Current Zoning: N1-C (neighborhood 1-C).  
Proposed Zoning: N2-A(CD) (neighborhood 2-A, conditional)

Approximately 4.09 acres located along the north side of Hovis Road, west of Wildwood Avenue.

The petition proposes the development of up to 39 multi-family attached dwelling units. The site is currently undeveloped.

SCHEMATIC SITE PLAN

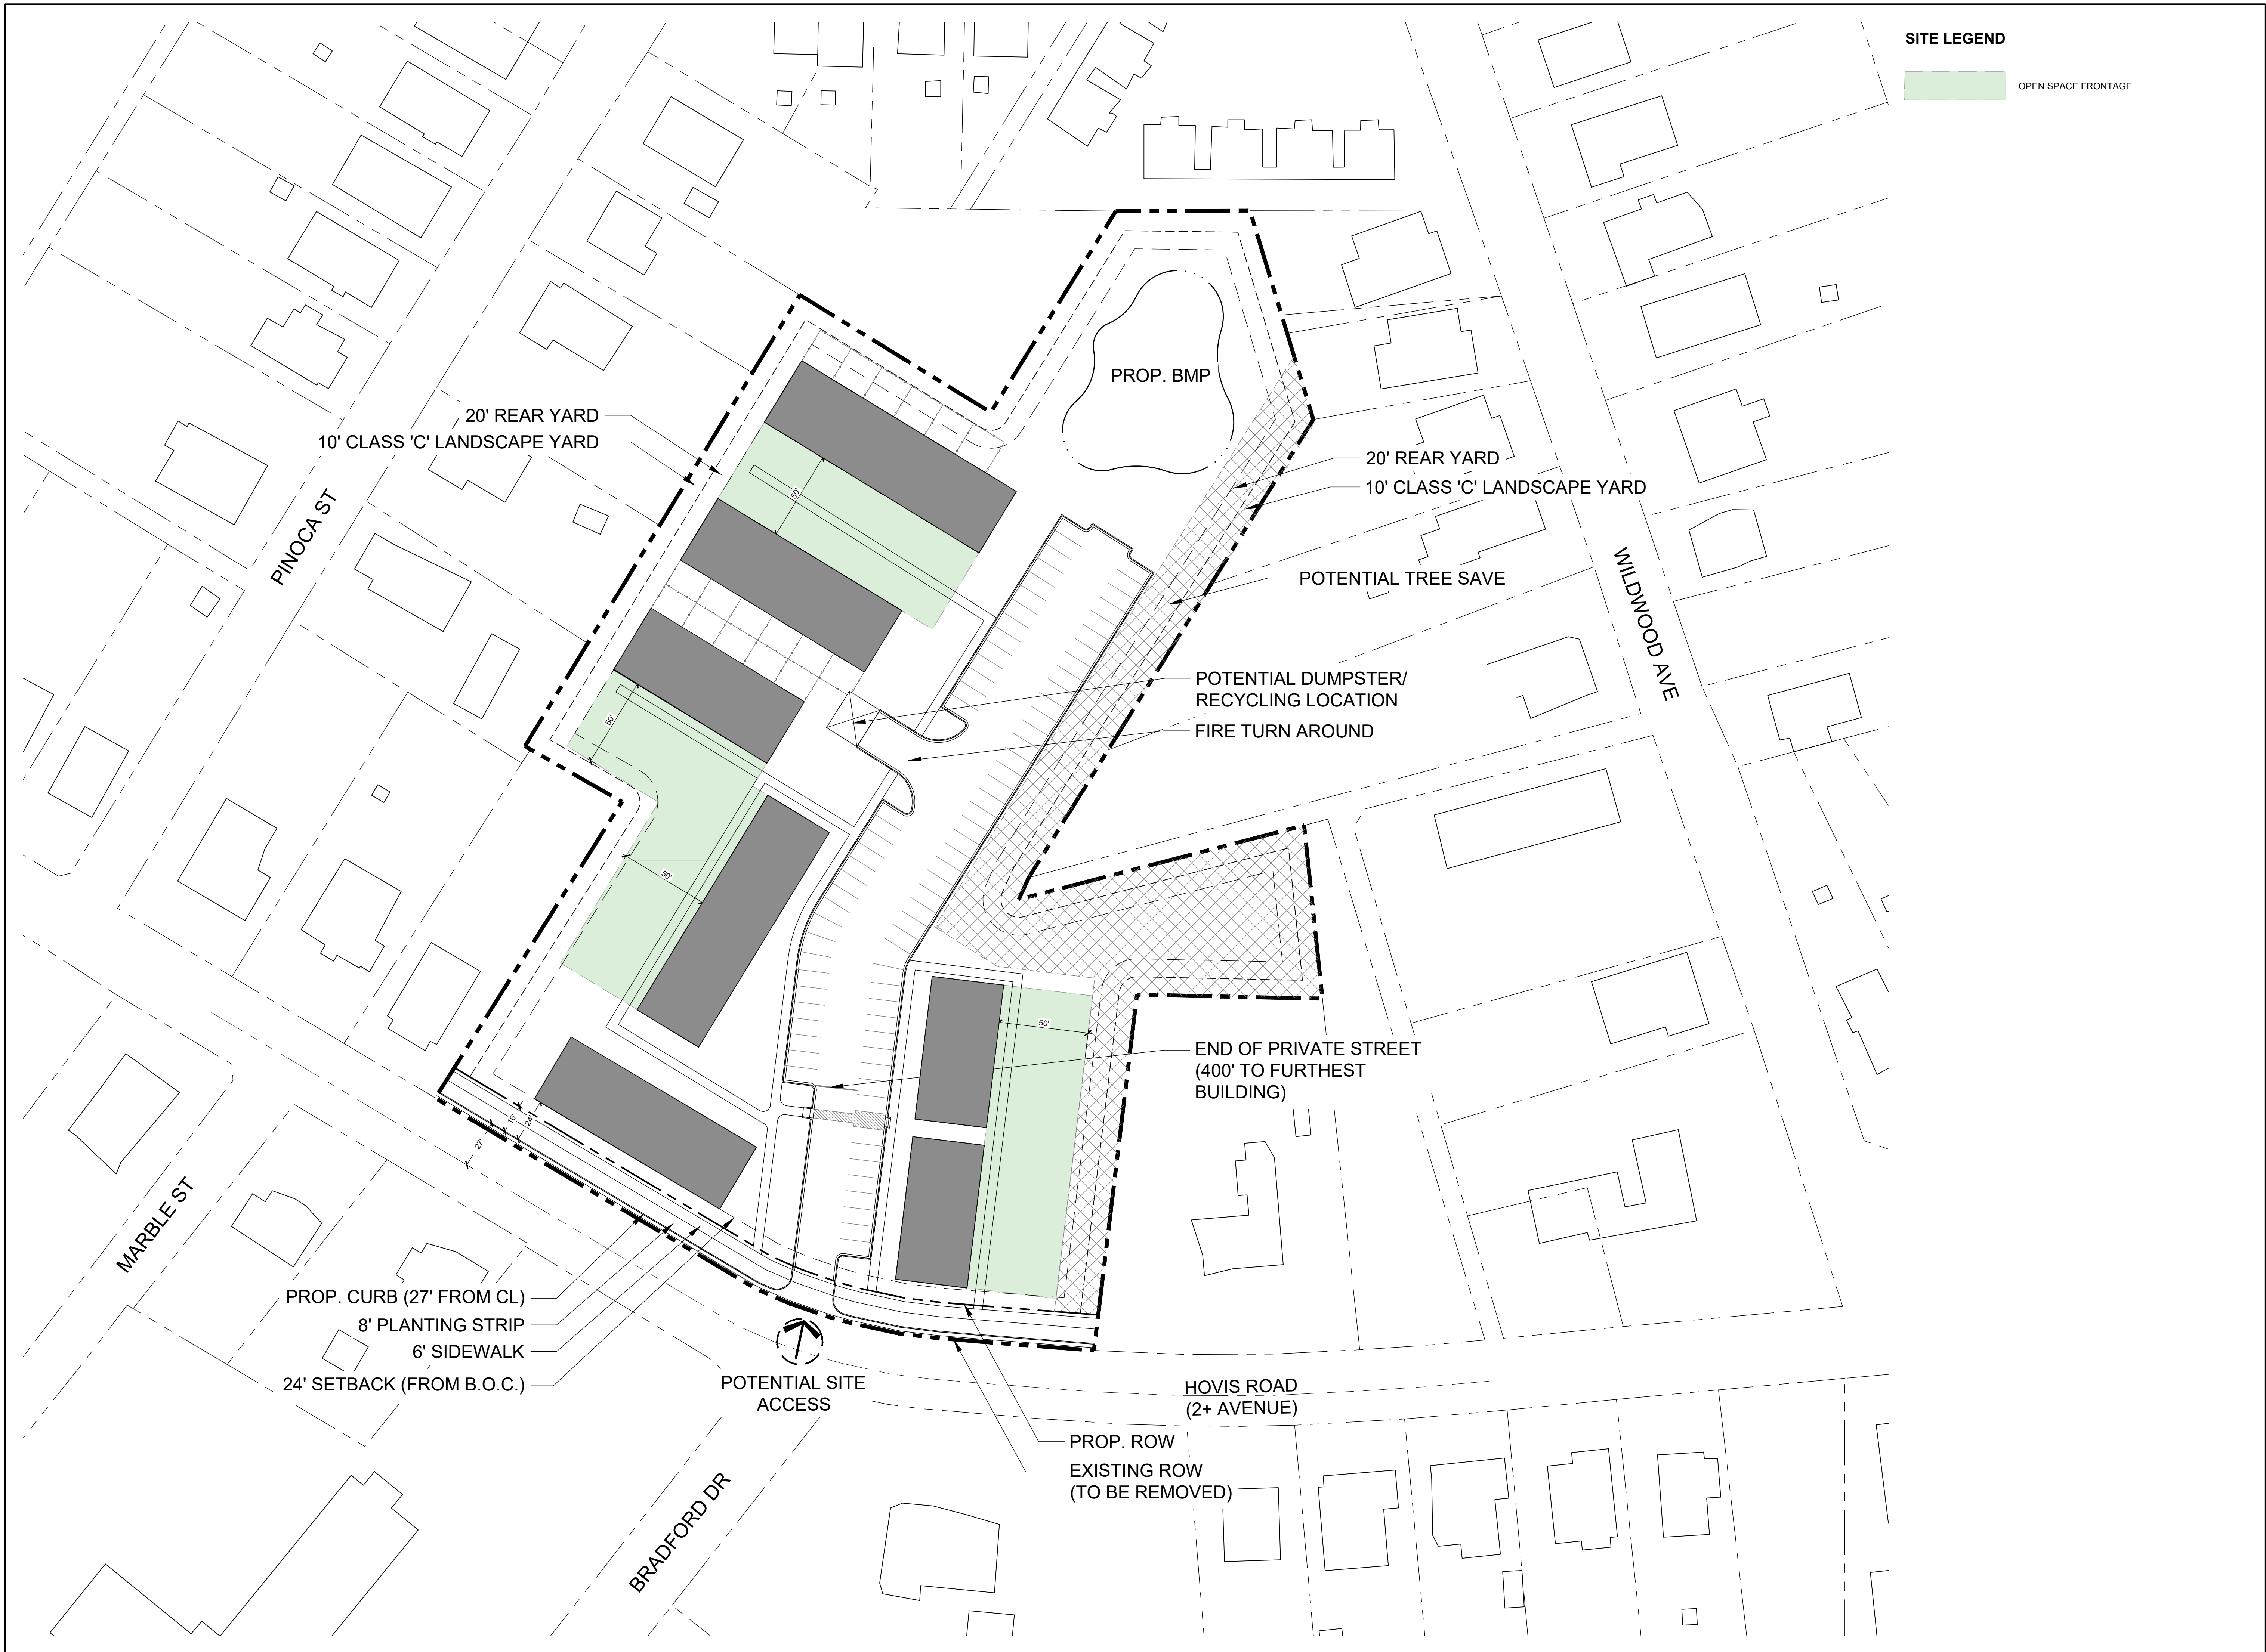
2. ~~Housing and Neighborhood Services: under General Provision 3.a the proposed text "House CLT" should be amended to "House Charlotte Program."~~ Addressed
  3. Entitlement Services: the large central parking area does not match the character of the neighborhood. The parking lot should be reconfigured to breakdown the scale of the parking.
  4. ~~Entitlement Services: the height of buildings abutting properties in the Neighborhood 1 Place Type should be reduced to 40 feet.~~ Addressed
-
